Date: 30 March 2026
Our Ref: 13626

THE NET ZERO TEESSIDE ORDER 2024 (S.I. 2024 NO. 174) AS CORRECTED BY THE NET ZERO TEESSIDE (CORRECTION) ORDER 2024 (S.I. 2024 NO. 1384) AND AS AMENDED BY THE NET ZERO TEESSIDE (AMENDMENT) ORDER 2025 (S.I. 2025 NO. 1143) (THE 'ORDER')

PROPOSED APPLICATION FOR A NON-MATERIAL CHANGE IN RESPECT OF SCHEDULE 15 (DESIGN PARAMETERS) OF THE ORDER

Drawing Number	Rev
<b>60559231-PE-DRG-001</b>	<b>2</b>

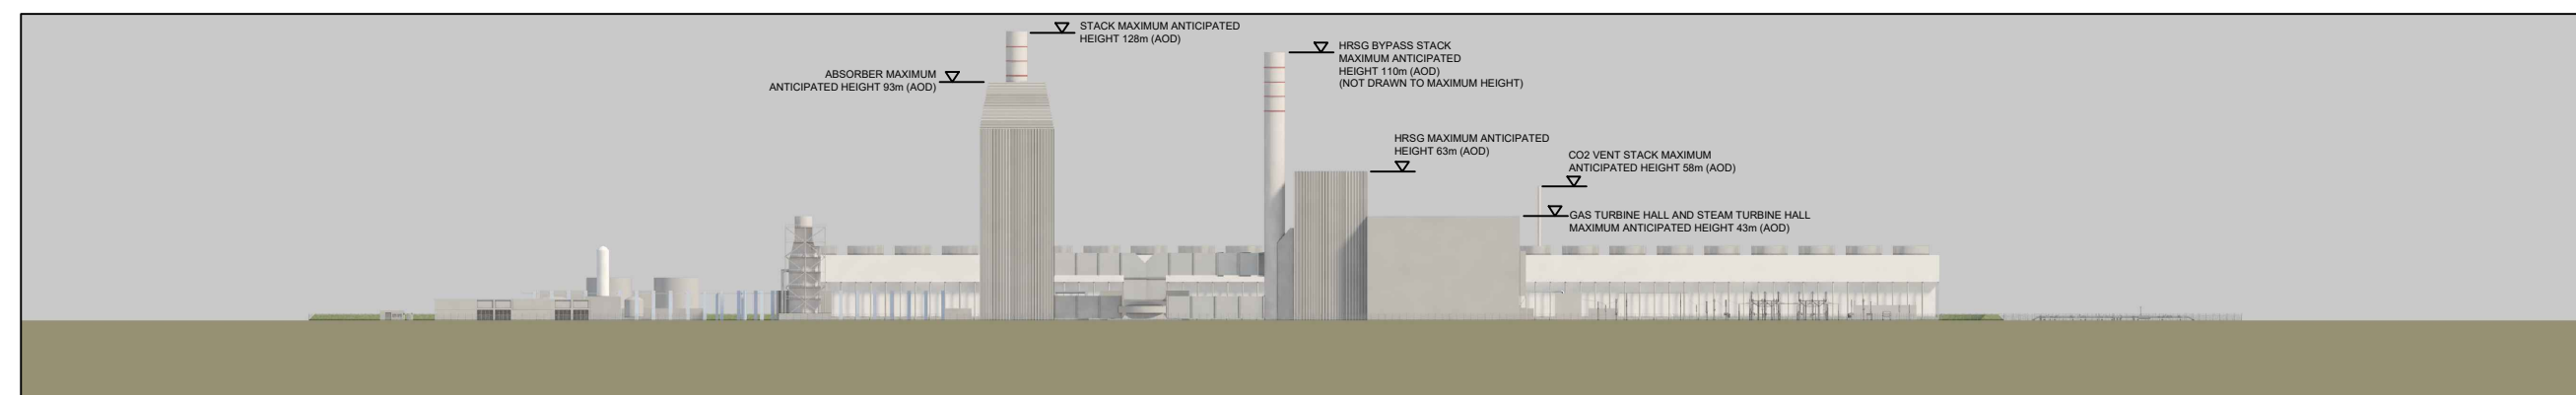
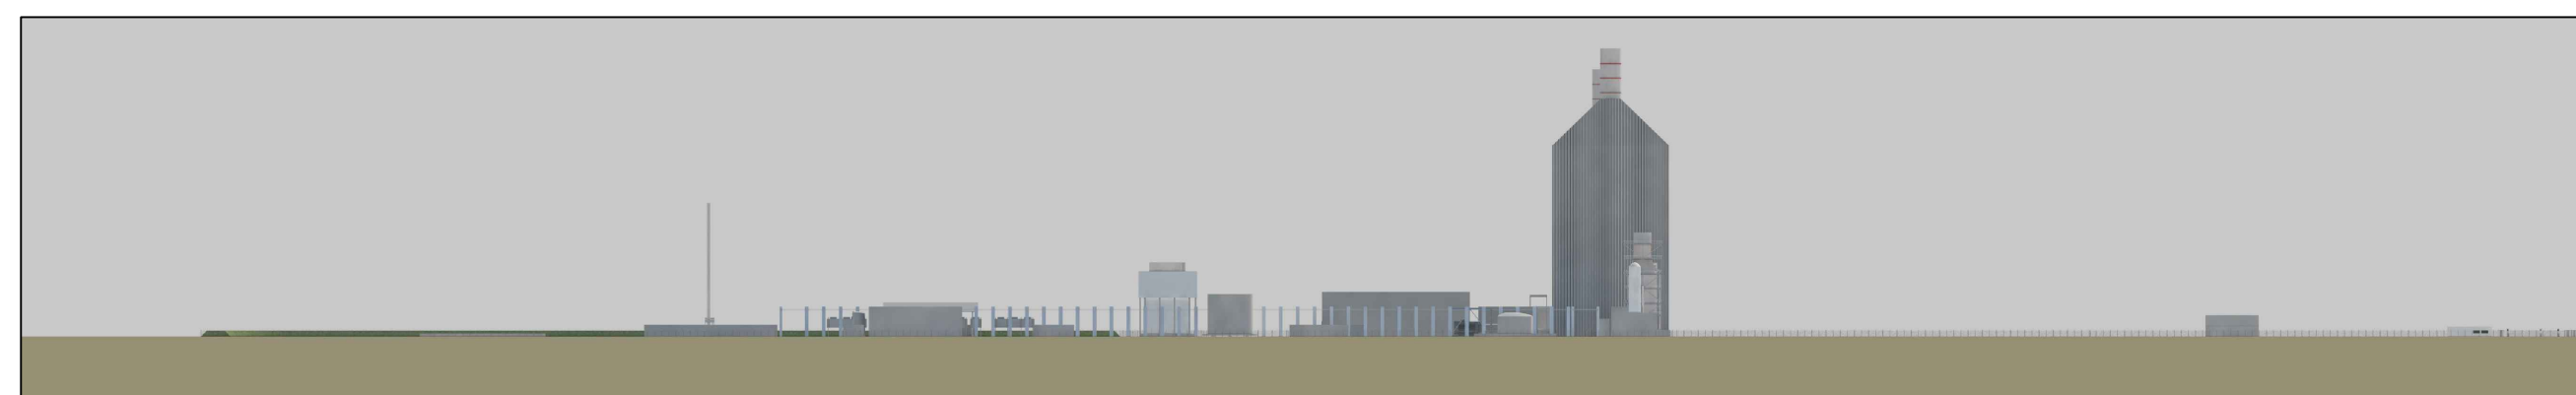
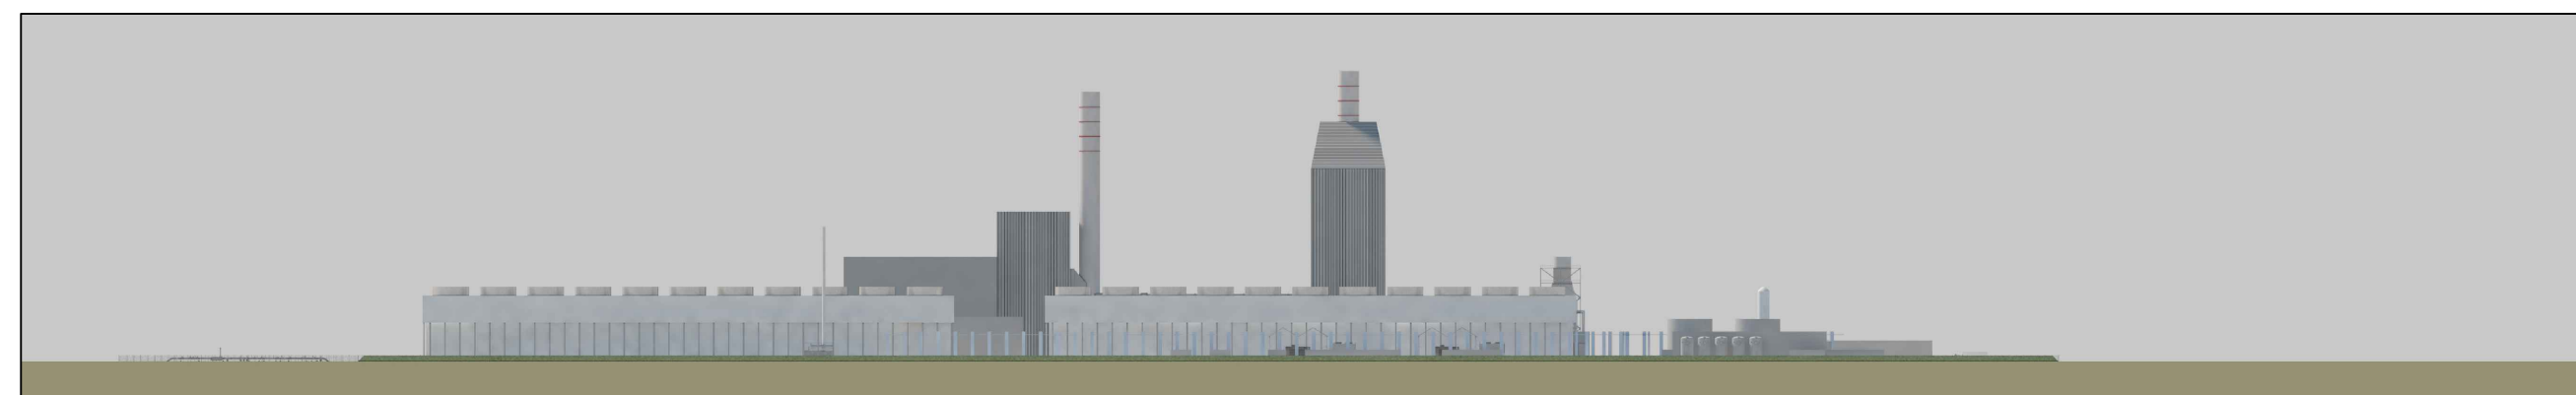
- Change No. 1: Change to design parameters
 - Change (i): Increase in the maximum inner diameter of the absorber stack from 6.6 metres ('m') to 7.0 m.
 - Change (ii): Increase in the maximum inner diameter of the Heat Recovery Steam Generator (HRSG) stack from 6.5 m to 9.0 m.

For both stacks, the change to the inner diameter corresponds to an equivalent change to the outer diameter, as the stacks comprise single-wall steel sheet construction.
